STATE OF NORTH CAROLINA
DEPARTMENT OF TRANSPORTATION

September 2, 2021

Subject: **Request for Modification for Section 404 Regional General Permit No. 201902350 and Section 401 Water Quality Certification** for the Interstate 485 (I-485) improvements from I-77 to US 74 (Independence Boulevard), Mecklenburg County, Division 10, TIP I-5507. Debit \$570.00 from WBS 43609.3.2.

The purpose of this letter is to request modification of the United States Army Corps of Engineers (USACE) Section 404 Regional General Permit 201902350 (RGP 50) and associated North Carolina Division of Water Resources (NCDWR) Section 401 Water Quality Certification for the above referenced project.

SITE #3

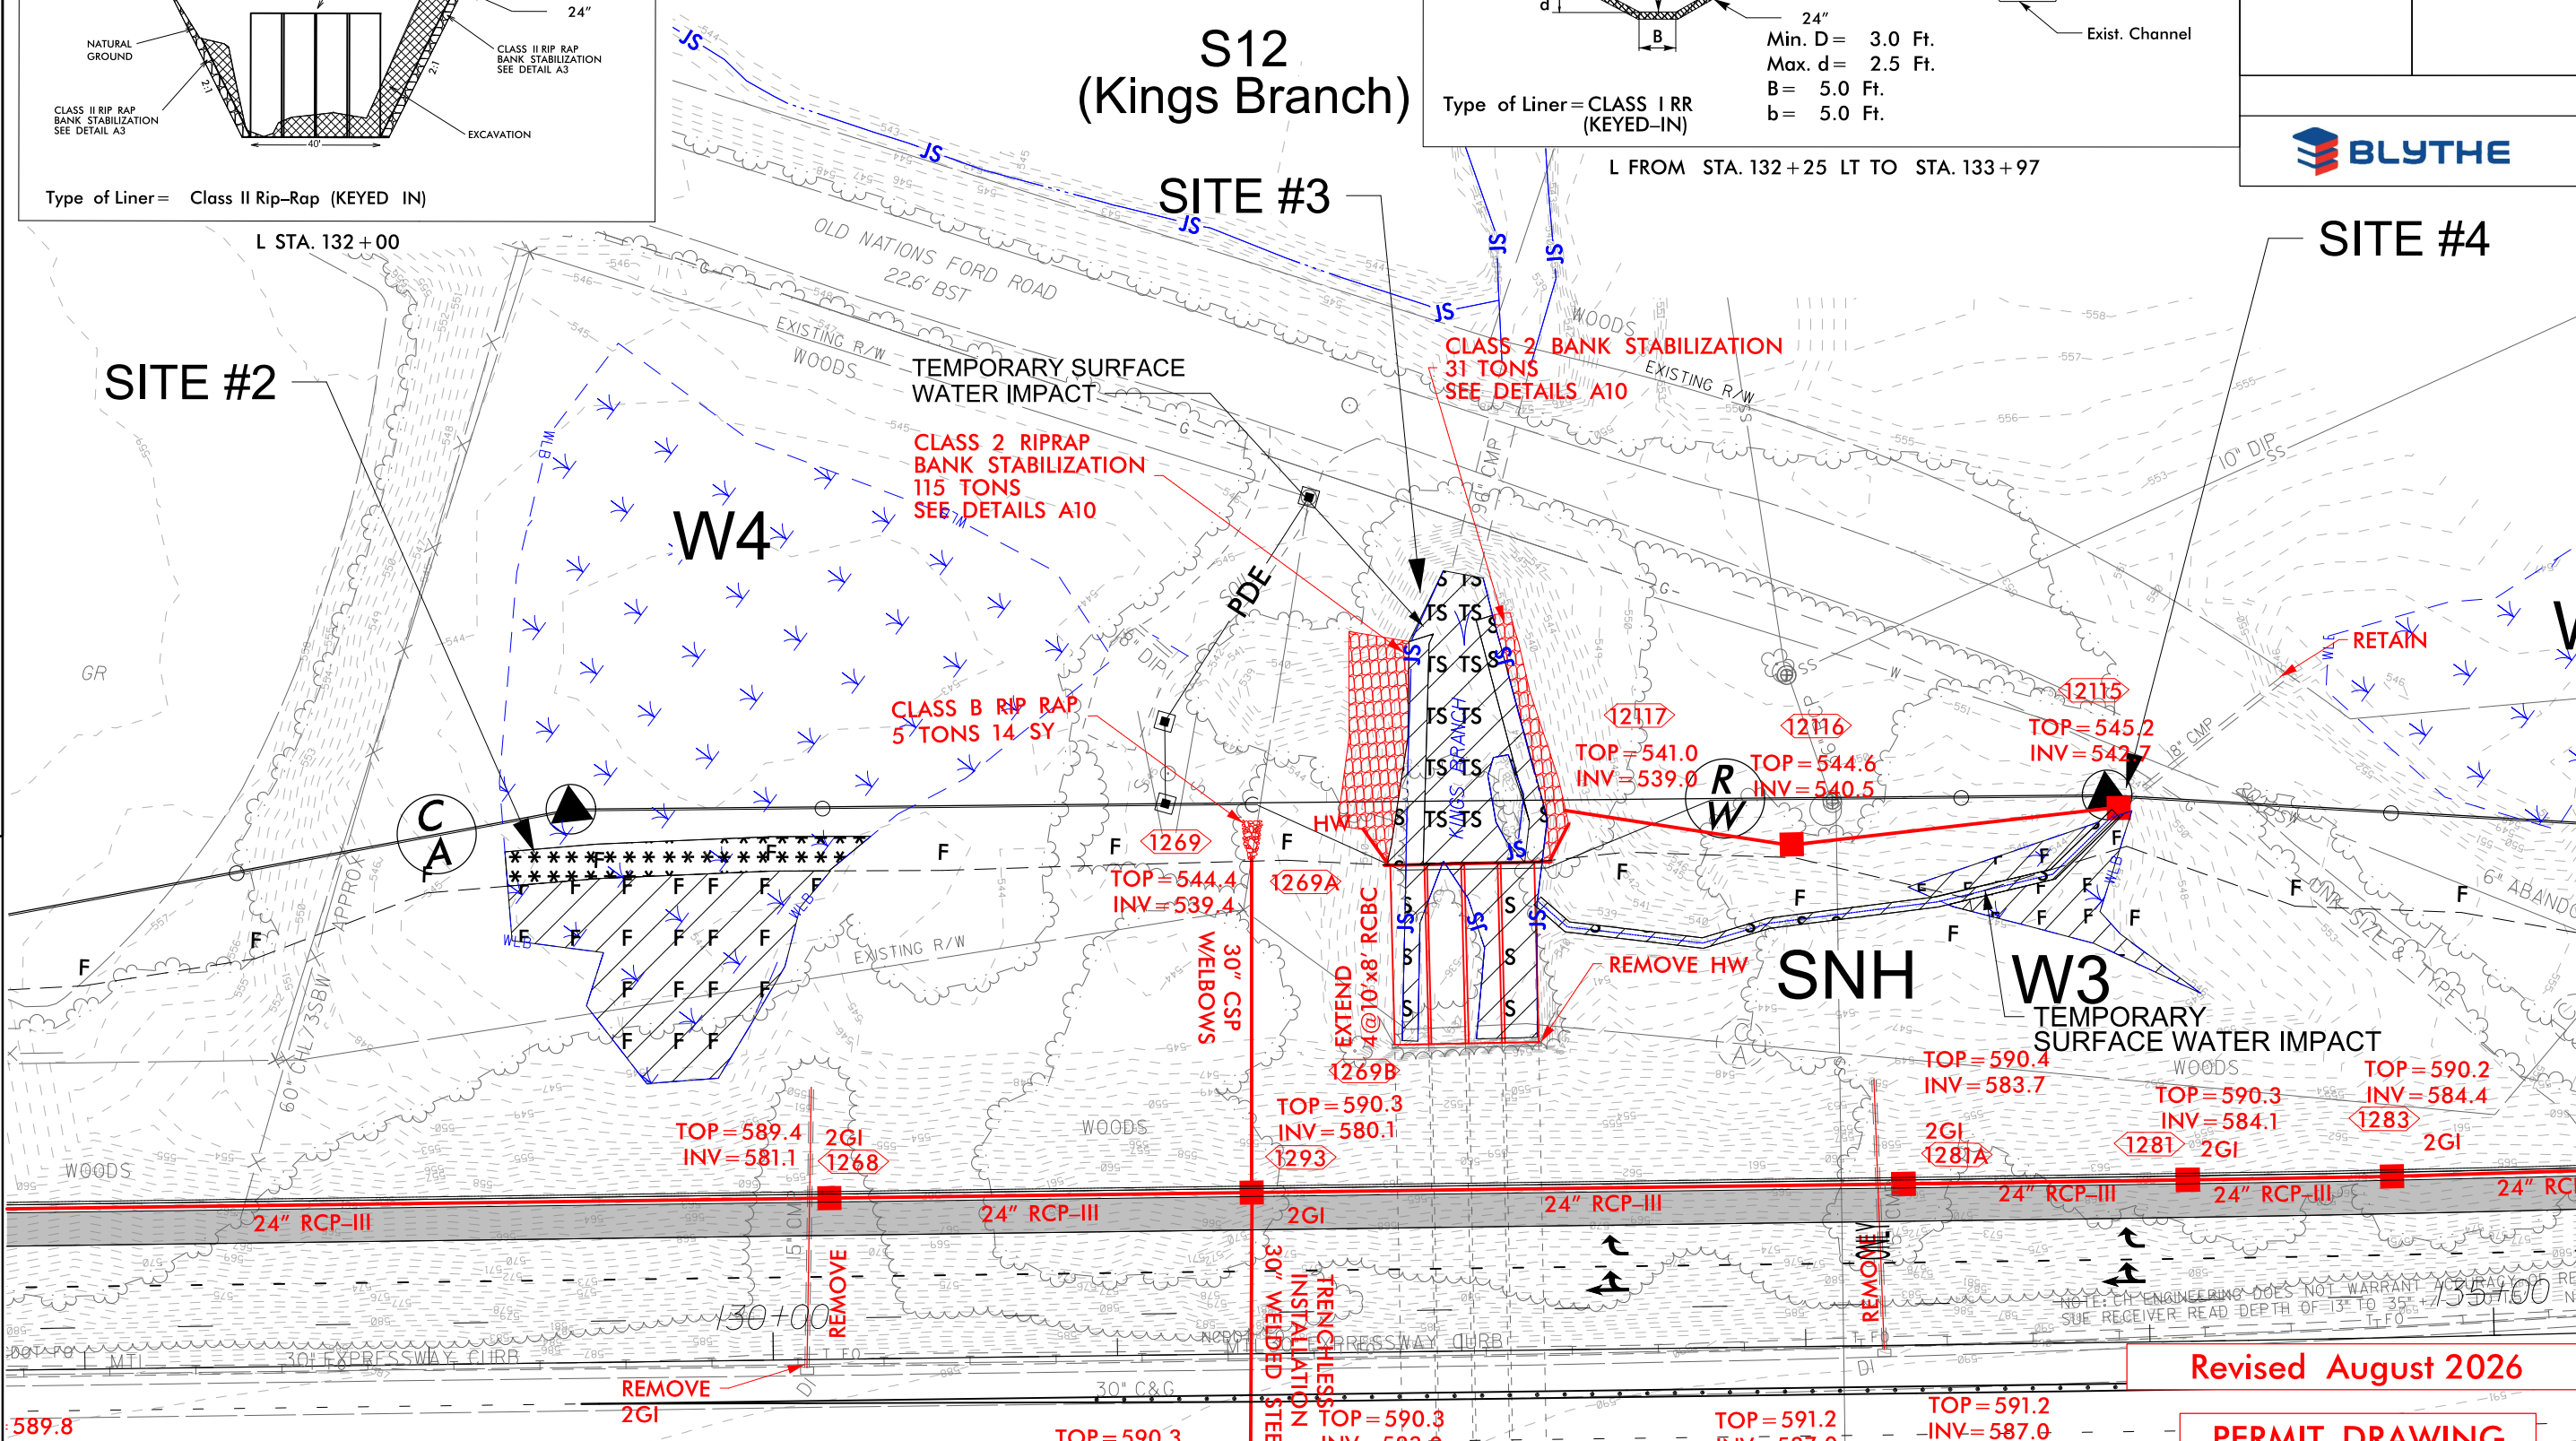
Site 4

A permit modification was approved for this site on November 12, 2020 that included design revisions to the originally permitted roadway fill slopes and channel change in this location to avoid impacting the existing sanitary sewer line. It has since been determined that the sanitary sewer line will need to be replaced; therefore, the proposed design will revert to a 2:1 roadway fill slope as was included in the original permit (approved by the USACE on December 18, 2019 and NCDWR on December 2, 2019). The previous permitted design shown in the permit modification included <0.01 acre of permanent wetland fill impacts due to roadway fill, <0.01 acre of permanent wetland fill impacts due to the channel change, and 0.02 acre of mechanized clearing impacts to wetland W3. Stream impacts totaled 130 linear feet of permanent stream channel impacts, including 95 linear feet due to roadway fill and 35 linear feet due to the channel change,

as well as 10 linear feet of temporary fill impacts to stream SNH. The proposed design will result in a total of 181 linear feet of permanent stream channel impacts to stream SNH, including 159 linear feet due to roadway fill and 22 linear feet due to the channel change, and no temporary stream impacts. Proposed wetland impacts will be 0.03 acre, including 0.02 acre of permanent wetland fill impacts due to roadway fill, <0.01 acre of permanent wetland fill impacts due to the channel change, and no mechanized clearing impacts in wetlands. The proposed design will result in an increase in permanent stream channel impacts of 51 linear feet and a decrease in temporary stream impacts of 10 linear feet. Overall total permanent wetland impacts to wetland W3 will remain 0.03 acre, although permanent wetland fill impacts have been increased to 0.03 acre and mechanized clearing impacts have been eliminated.
